Our Ref: CM/33/17/PL
Your Ref:

Town & Country Planning Act 1990 (as amended)
Town and Country Planning (Development Management Procedure) (England) Order 2015
Application for Planning Permission

Development Demolition of prefabricated former private school building and Mill Lodge residential unit. Refurbishment of existing Mill to retain and refurbish existing dwelling and flats 1 & 2 (adjoining) with 2No. additional dwellings.
Refurbishment of Mill Cottage and Mill Thatch (units 1 & 2) and erection of 1No. new-build floating pond-house within feature pond. Departure from the Development Plan. This application also lies within the parish of Littlehampton.

Location Clymping Mill Clymping Street Clymping

Project Name: The Mill Buildings Climping	
Drawing No. 2	Drawing Title: Existing Site Plan
Date: 11/12/2017	
Scale: 1:200 @A1

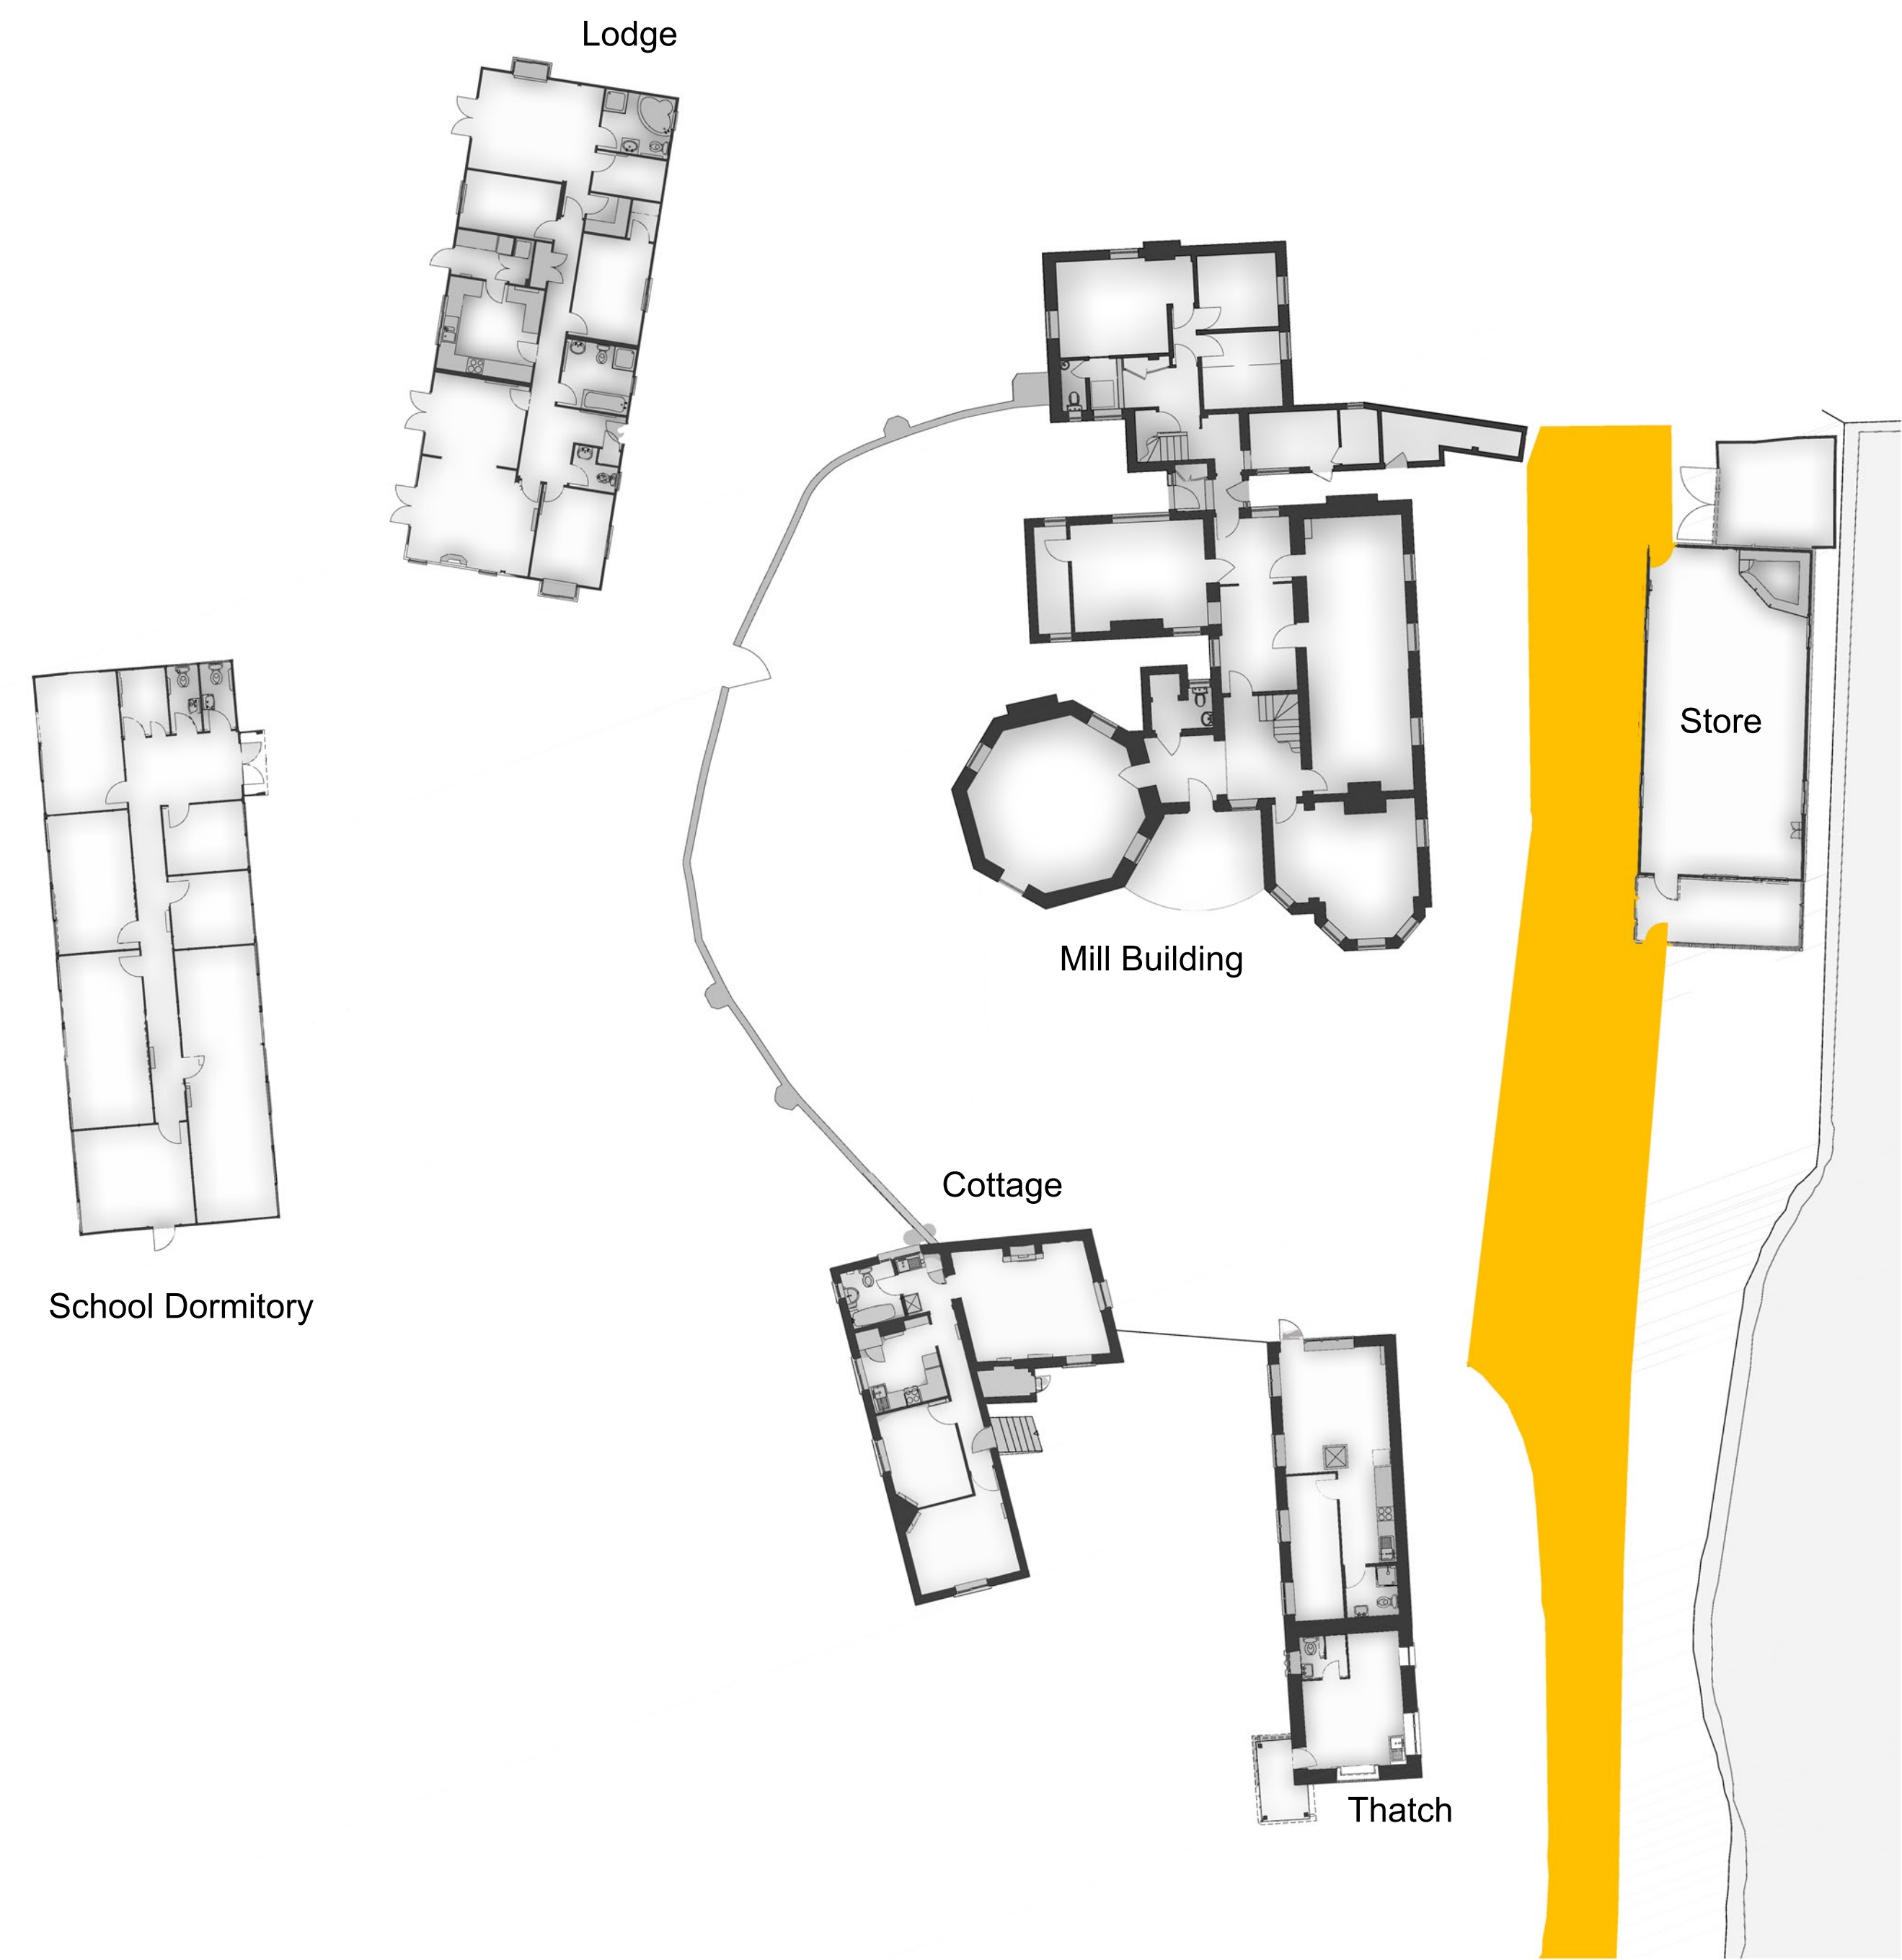
Block Plan - Amend

Please submit 1 electronic or 3 paper copies of an amended block/site plan at a scale of 1:500 or 1:200 to include dimensions to the boundary from the proposal. Further details of what must be included on the plan can be found in the National Validation Requirements.
